Our ref: 26_35832_P

Your ref: H22-0566-26

Site Location: Land east of Delgate Bank Weston Spalding

Summary of Proposal: Erection of a free range egg laying unit including egg packing and storage building, feed silos and associated infrastructure

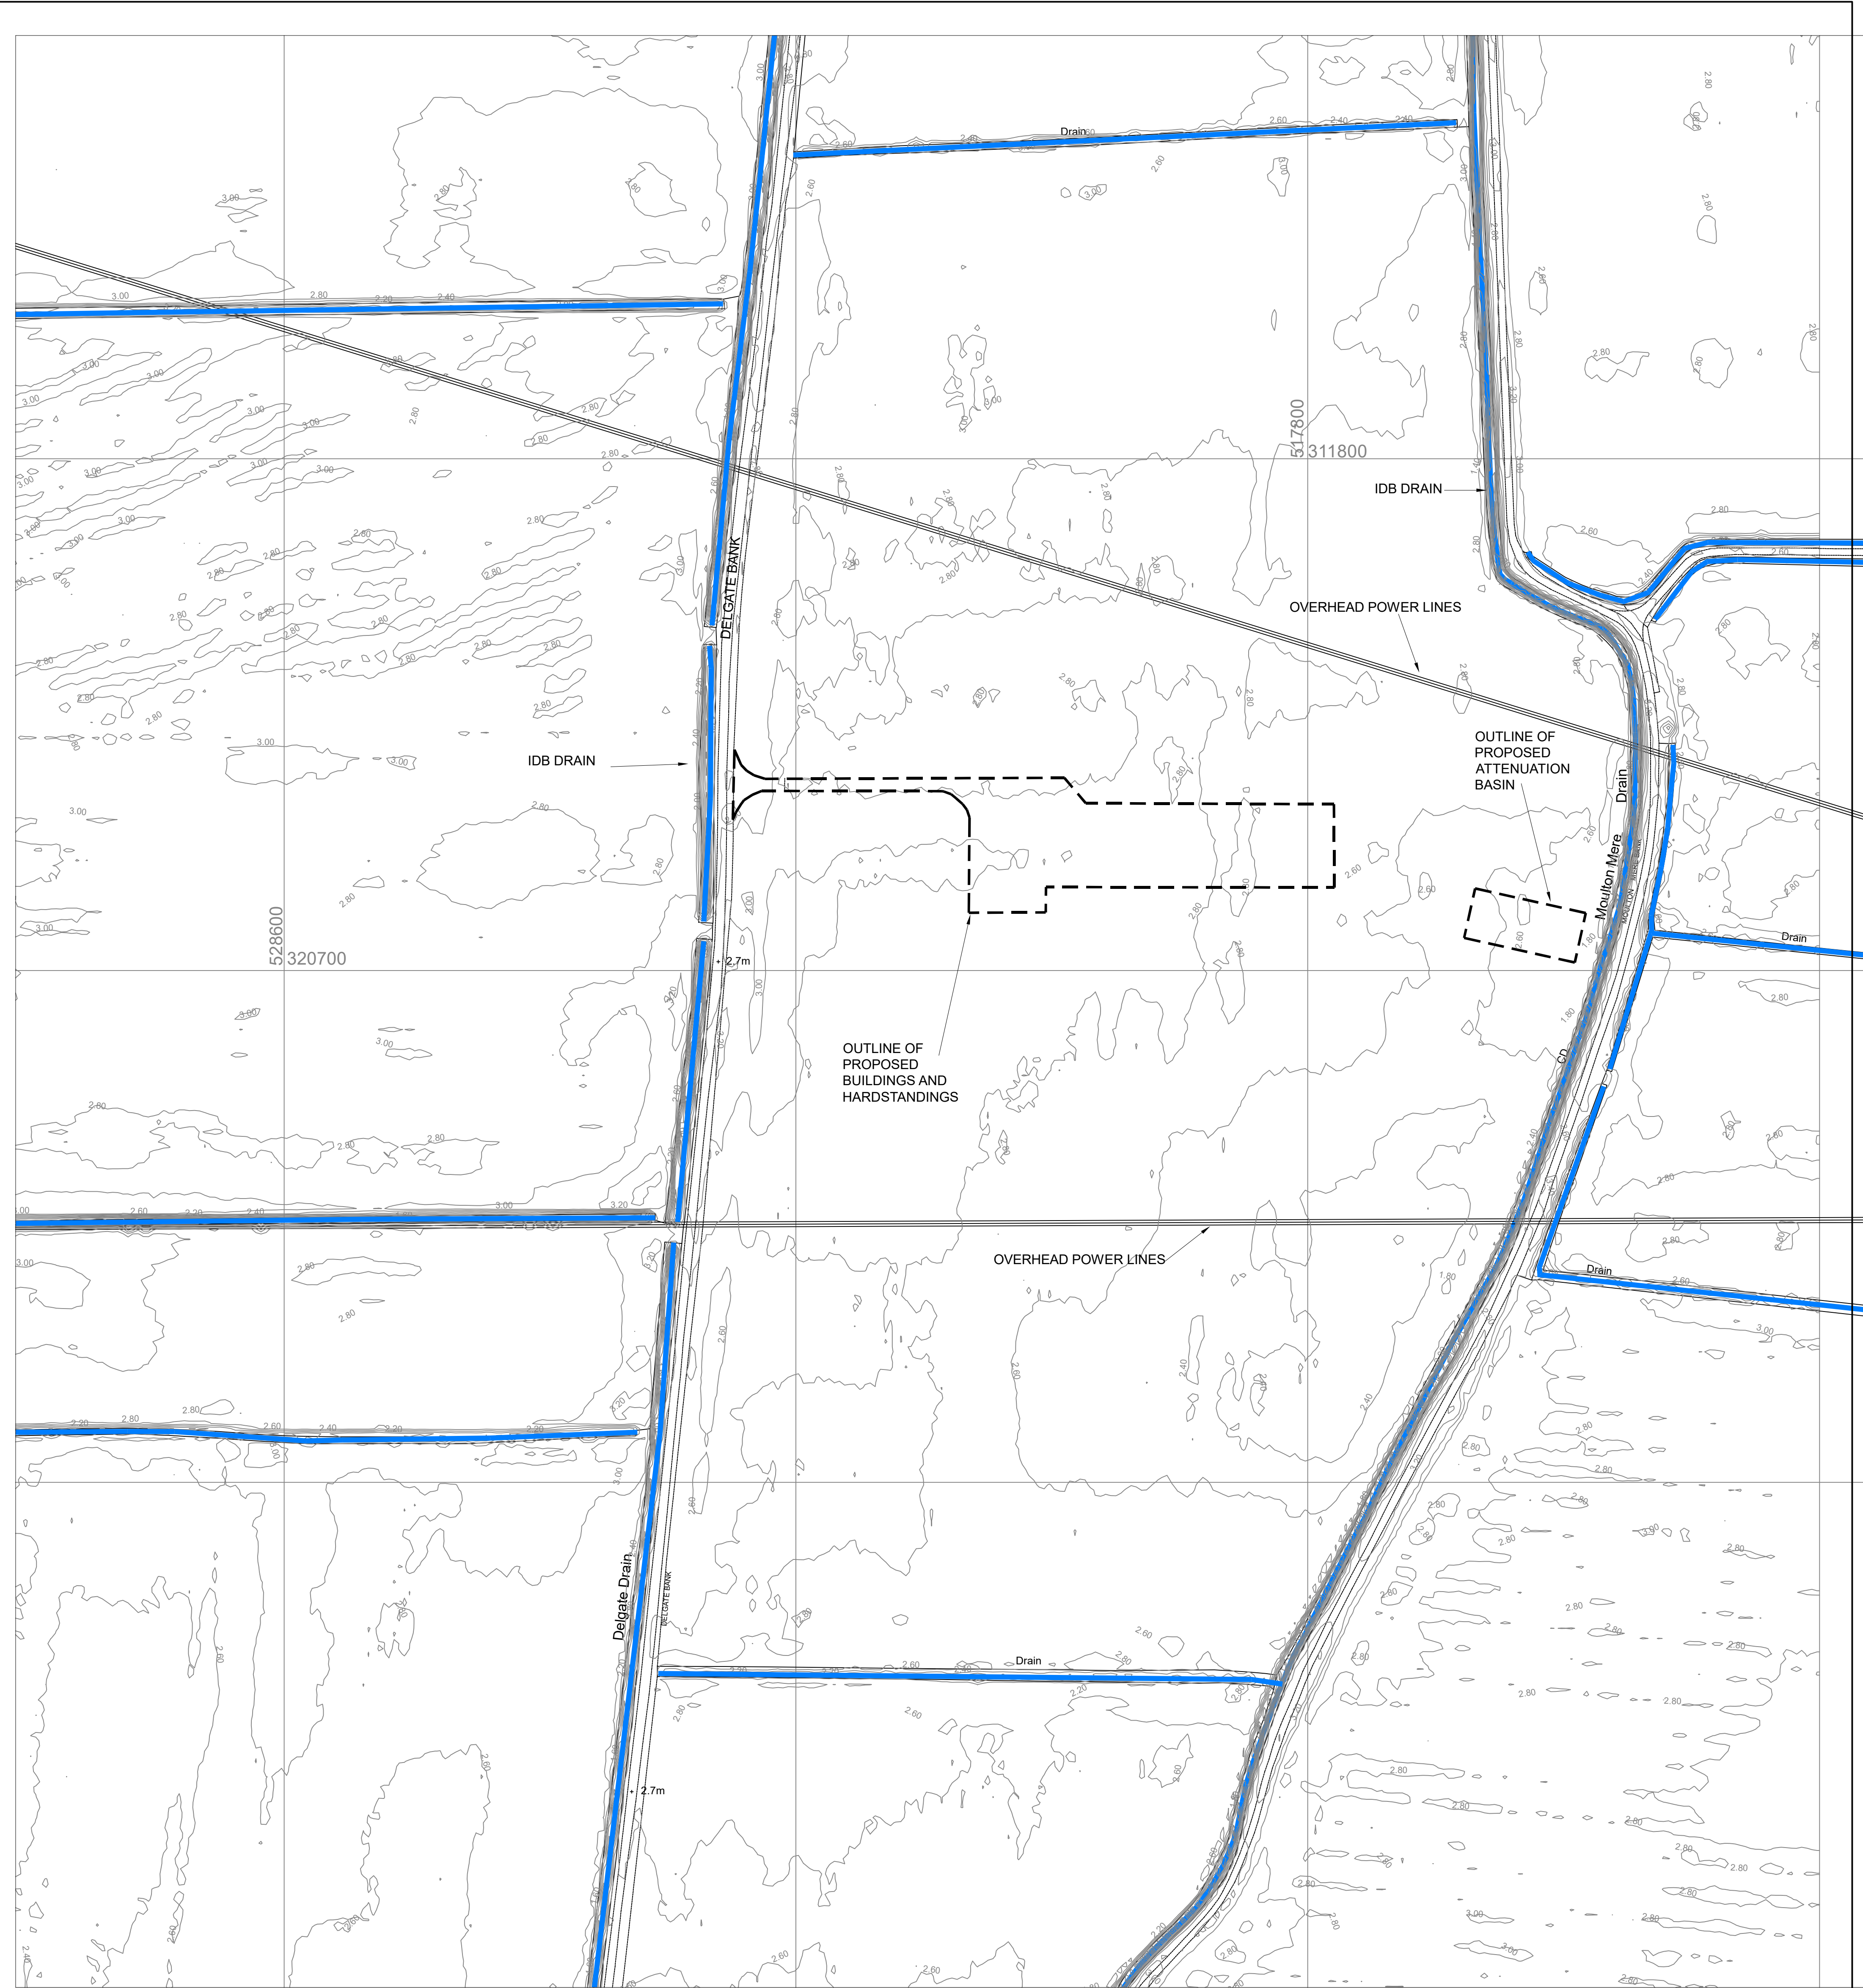
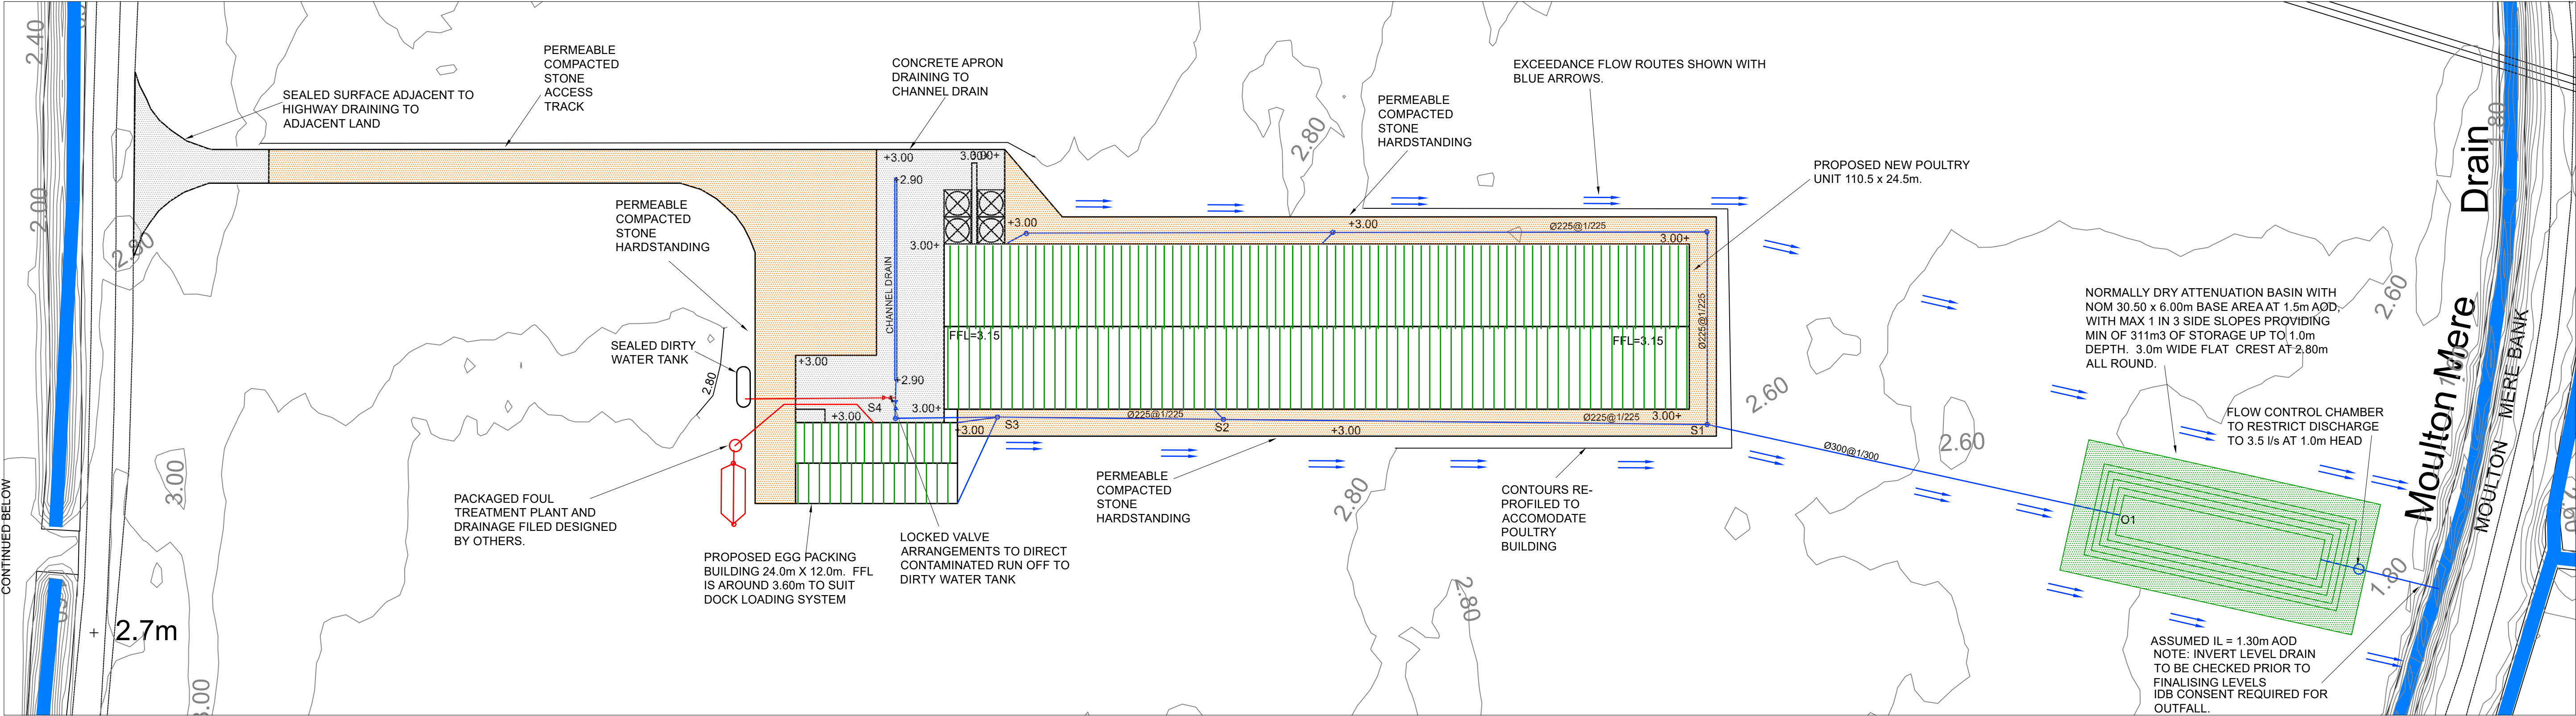
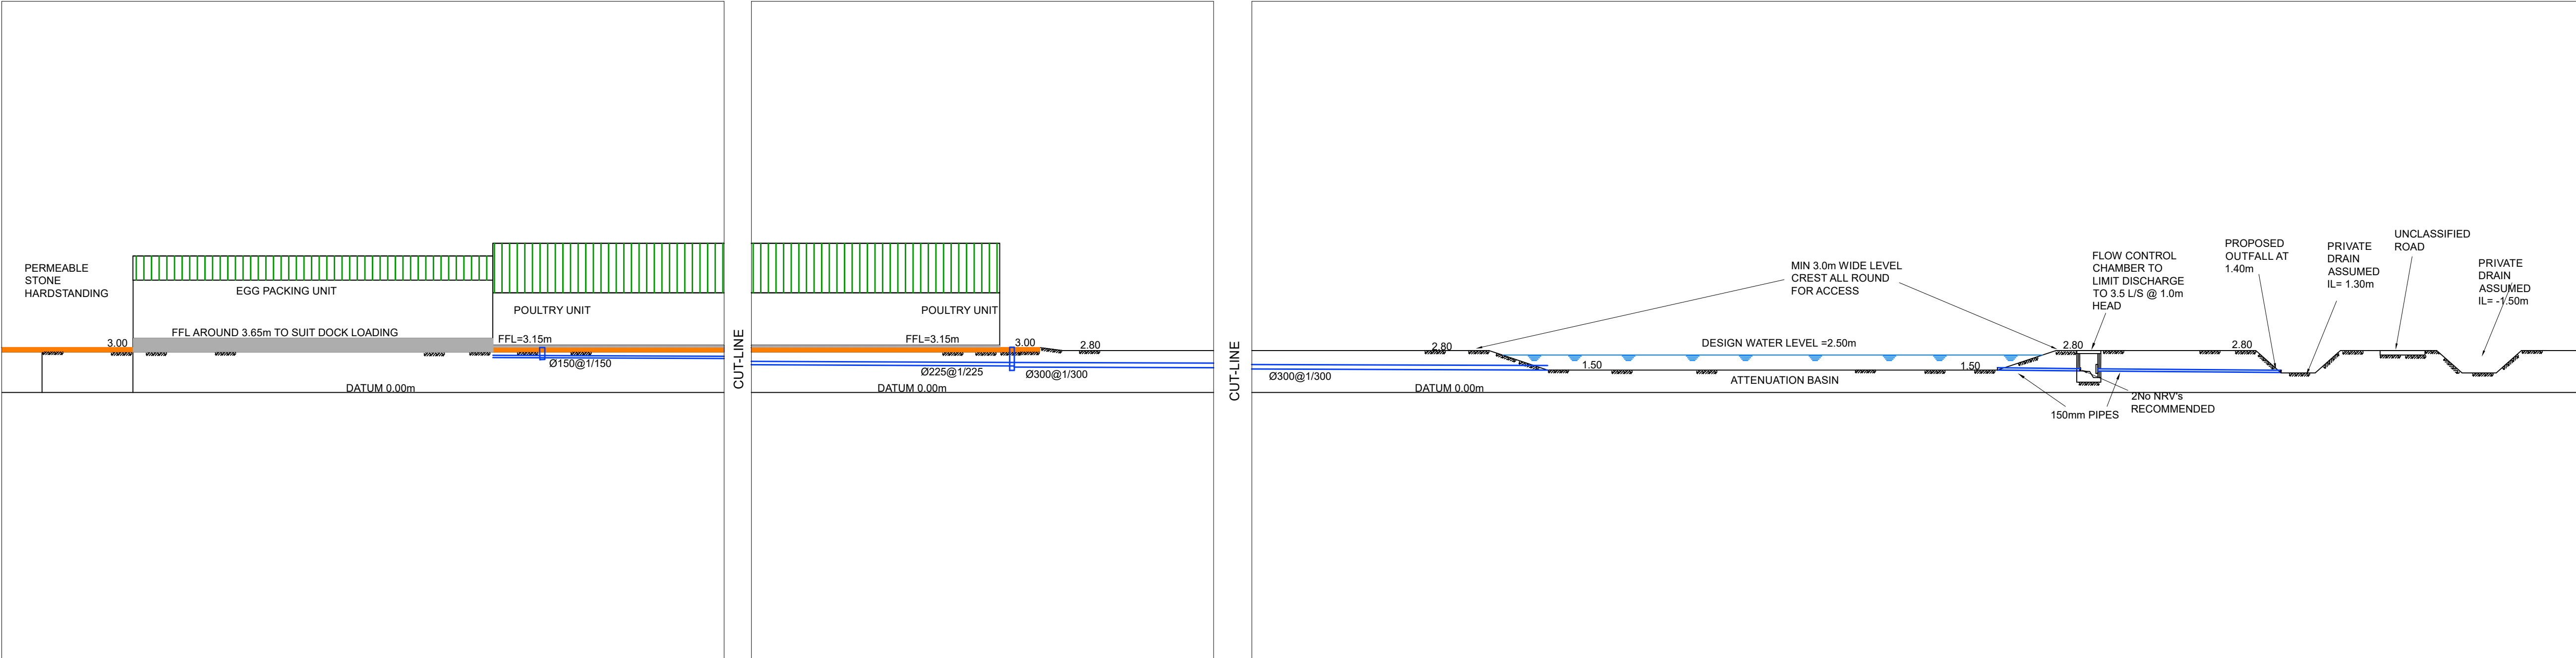
The 'Proposed Development and Outline Surface Water Drainage Design' drawing (881-002, George Shuttleworth Ltd, May 2026) indicates an assumed ditch bed level of 1.30 mAOD and a proposed outfall invert level of 1.40 mAOD. The receiving watercourse has also been labelled as a 'private drain'. As noted above, this is a Board **owned** arterial watercourse. We strongly encourage the applicant to engage with the Board to confirm the existing bed and water levels of the watercourse to ensure that the proposed outfall will not become submerged. Should the outfall be submerged, the drainage design and associated calculations should be revised accordingly, with the system modelled for submerged discharge conditions and a suitable non-return flap valve incorporated into the outfall design.

Based on the information provided, it is currently unclear which works are located within 9 metres of the Board arterial watercourse. We would be grateful if the applicant could provide an updated plan clearly identifying the 9 metre Byelaw Zone. For the avoidance of doubt, this distance should be measured from the nearest brink/edge of the watercourse banks, rather than the water's edge.

Please note, the Board are unlikely to approve a Byelaw 10 consent application for the construction of an attenuation basin or any land raising, if these are proposed within 9 metres of the watercourse, as these features may impede future access for watercourse maintenance and operational activities.

Finally, as the proposed outfall from the attenuation basin will discharge directly into the Board arterial watercourse, it will be located within 9 metres of the watercourse. To enable this proposal, consent would be required under Byelaw 10, and we recommend that the applicant contacts our office to make an application for this consent at their earliest convenience.
